**WELWYN HATFIELD BOROUGH COUNCIL
EXECUTIVE DIRECTOR - PLANNING, PUBLIC PROTECTION AND GOVERNANCE**

Application No: 6/2021/1453/HOUSE
Location: 35 Northaw Road East Cuffley Potters Bar EN6 4LU
Proposal: Erection of a single storey side extension, insertion of new windows/doors on side and rear elevation and rear rooflight following the demolition of the side garage
Officer: Ms Emily Stainer

Recommendation: Granted

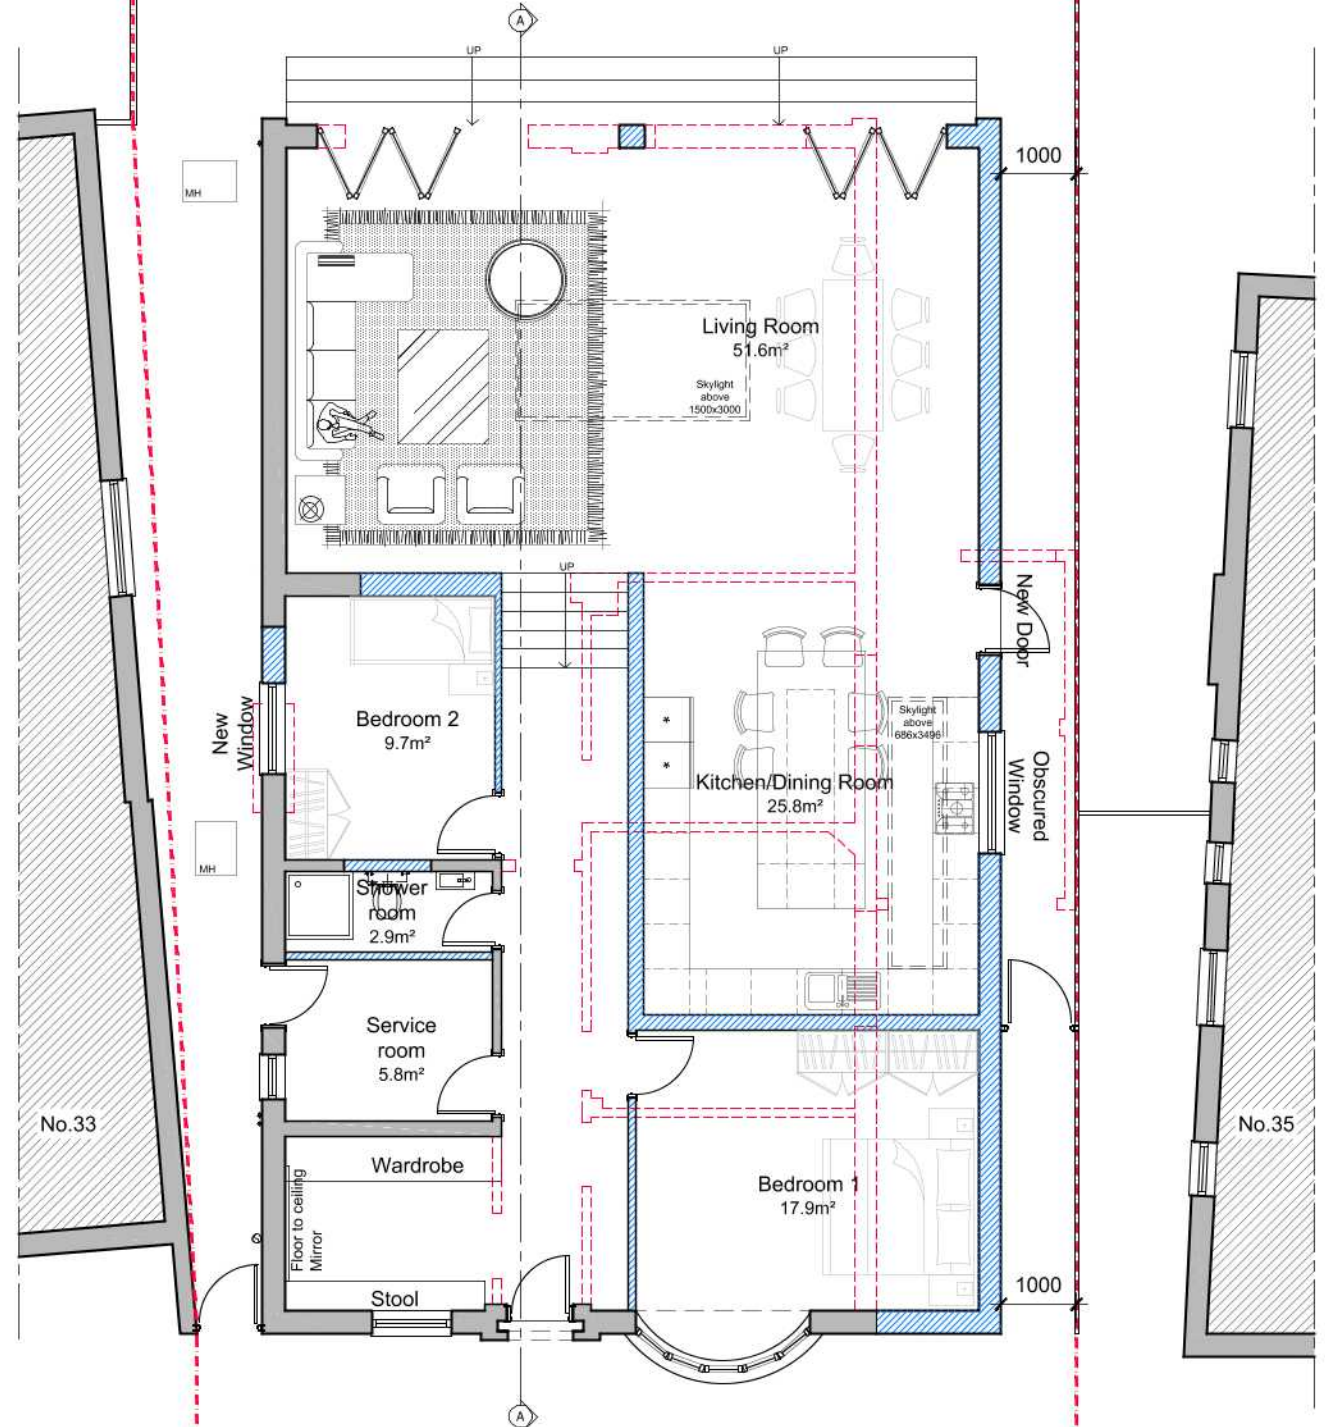
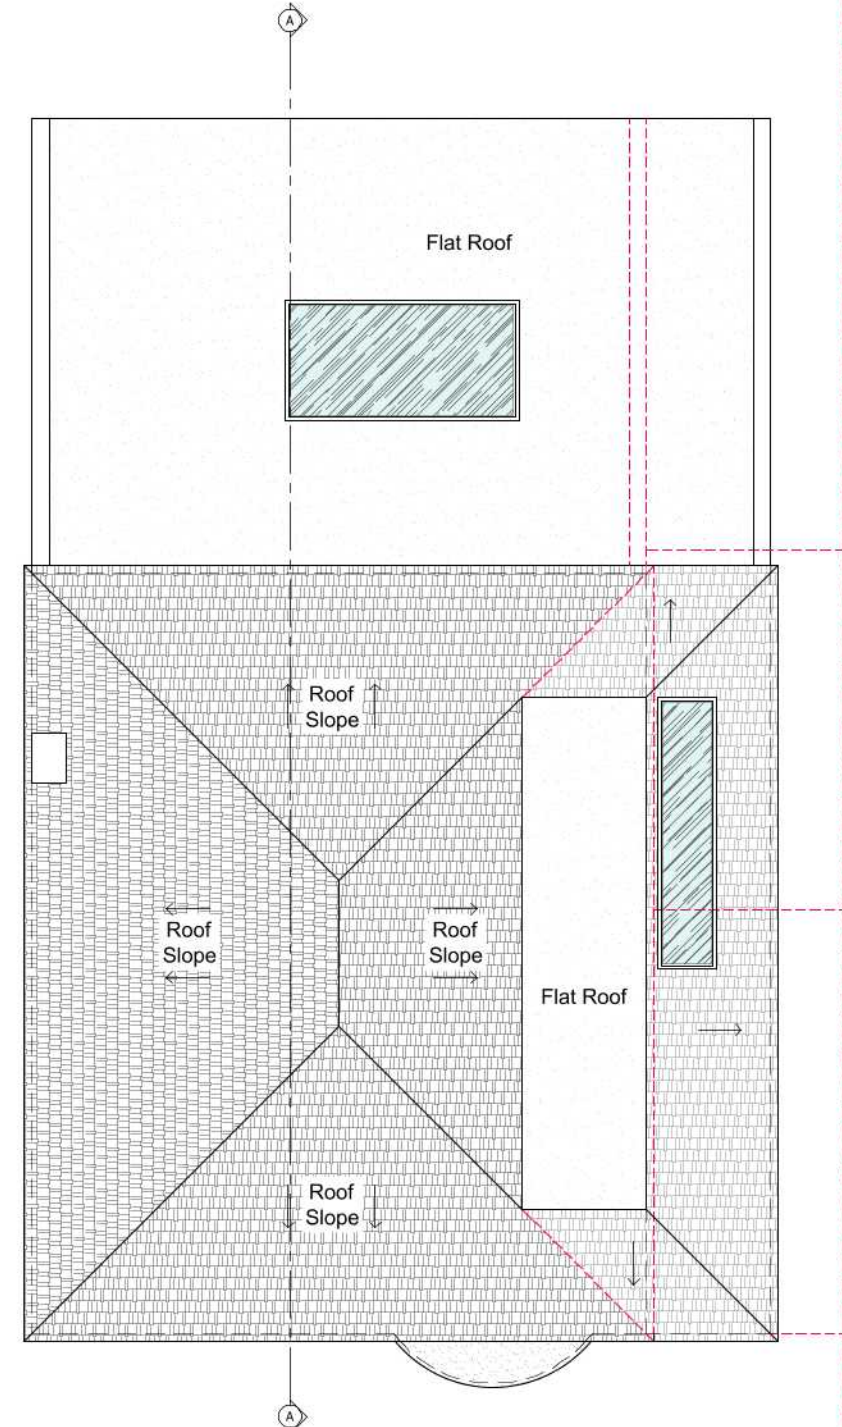
With regard to future occupiers, the location of bedroom 2 would be moved within the dwelling. The new window which would serve this bedroom would face the flank wall of 33 Northaw Road East, which is not normally reflective of a good outlook for the occupants of that room. In this case however, it is acknowledged that bedroom 2 as it currently exists already faces the flank wall of the neighbour on the opposite side. For that reason it would not be reasonable to refuse the application on the grounds of an unsuitable outlook.

The proposal would involve the demolition of the existing garage, which may result in a loss of a parking space. Whilst this may be the case, the internal alterations to the property will reduce the number of bedrooms at the dwelling from three to two. The requirement in the SPG for a 2-bedroom dwelling in parking zone 4 is 1.5 spaces per dwelling. The existing frontage has a driveway where it would be possible for 2 vehicles to park, therefore there are no objections raised.

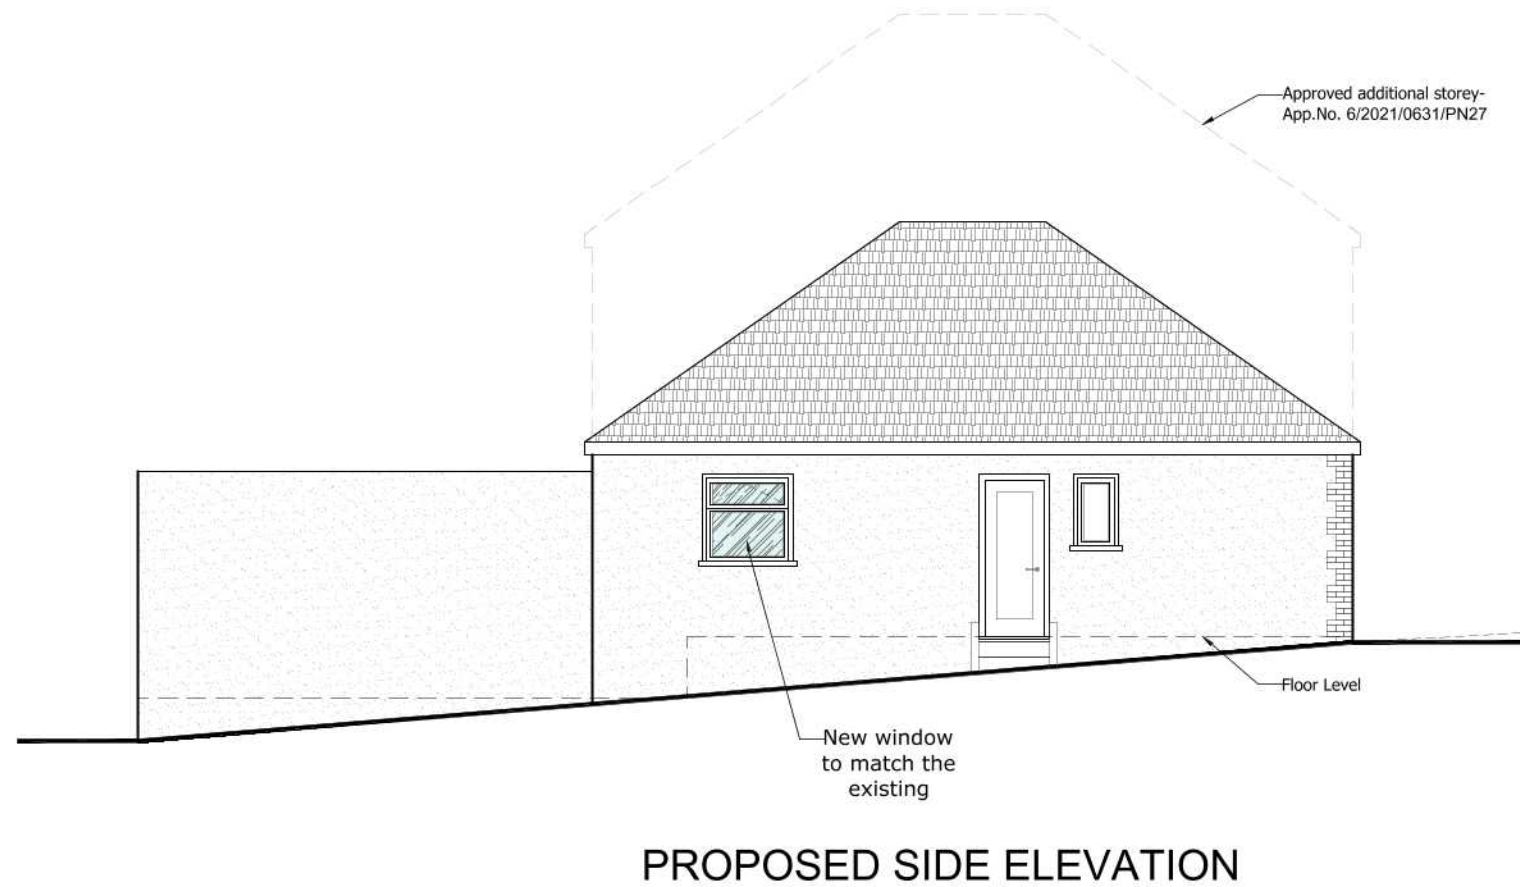
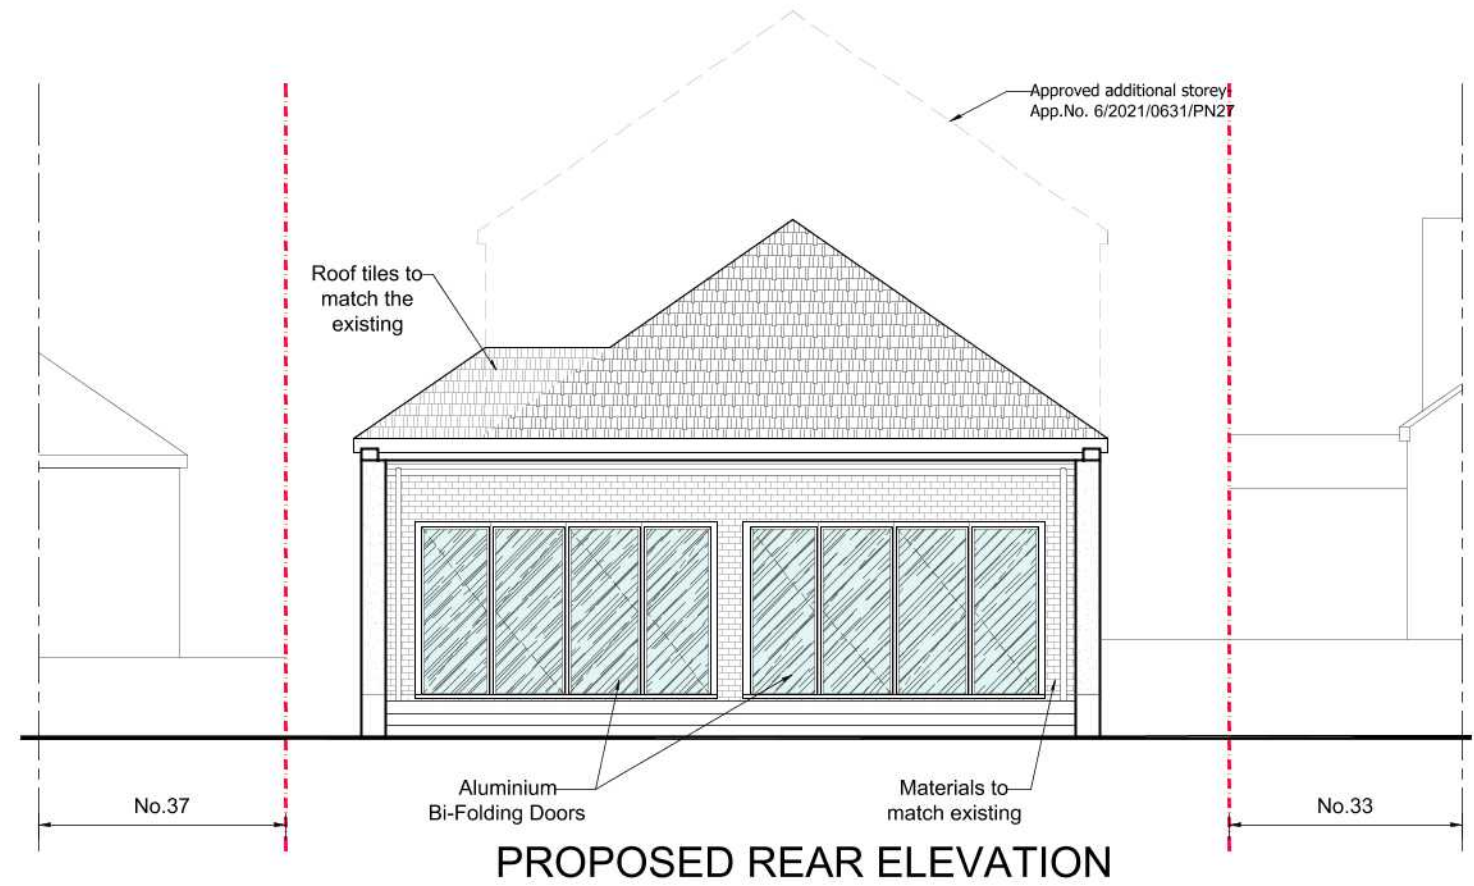
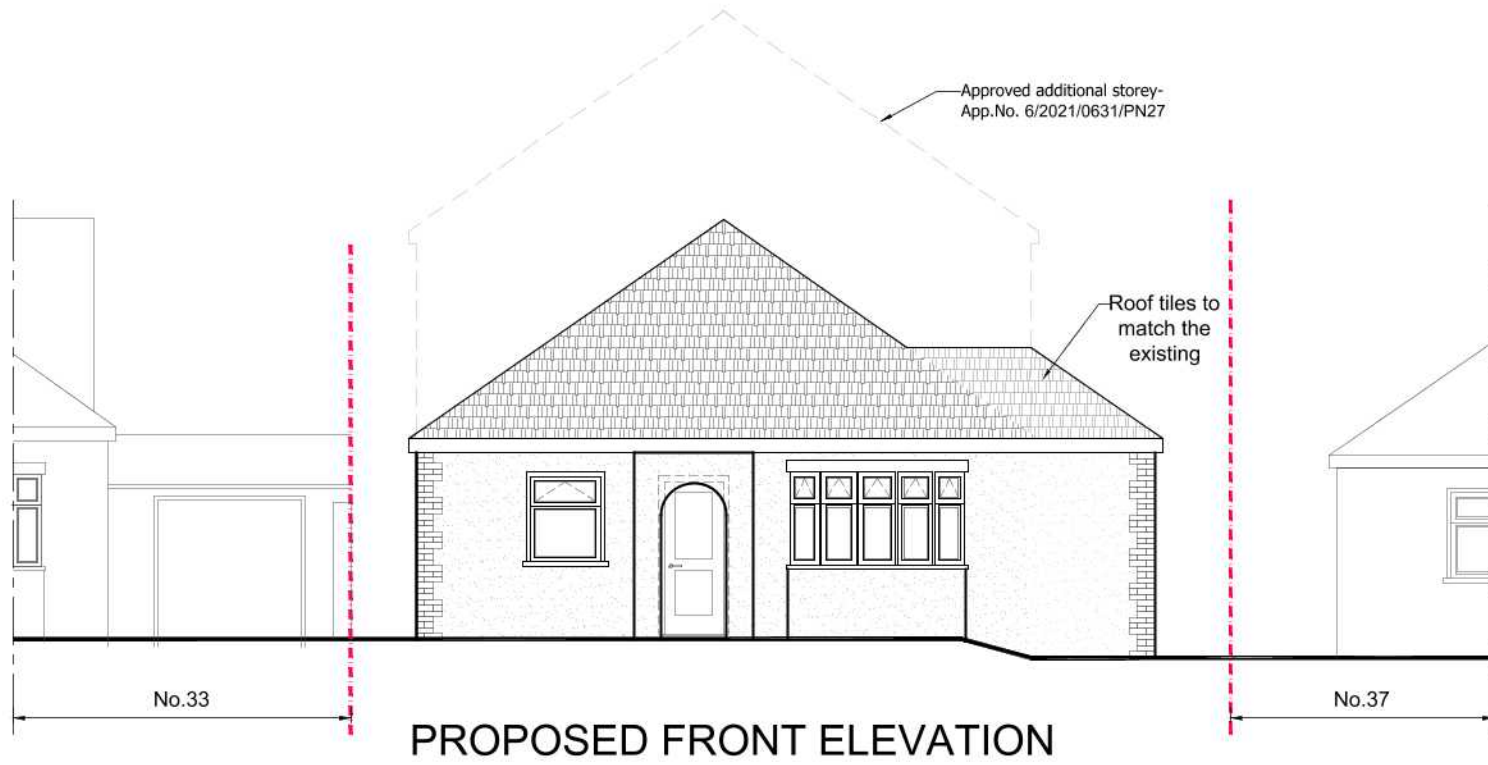
Comment (if applicable):			
<p>The proposed single storey side extension would replace an existing garage and car port which is finished with a mono-pitched roof, however it would extend the full depth of the existing property. It would also project by approximately 1.6m to the side. It would remain subordinate by virtue of its lower ridgeline and would integrate well with the design of the existing dwelling due to its hipped roof and continuation of the eaves. Whilst a small section of flat roof would also be required to facilitate the extension, in this case it is not considered to be detrimental to the character of the property or surrounding area. The proposed windows and doors are also of an acceptable design. The proposed materials would also match existing.</p>			
Would the development reflect the character of the dwelling?			
<input checked="" type="checkbox"/> Yes <input type="checkbox"/> No <input type="checkbox"/> N/A
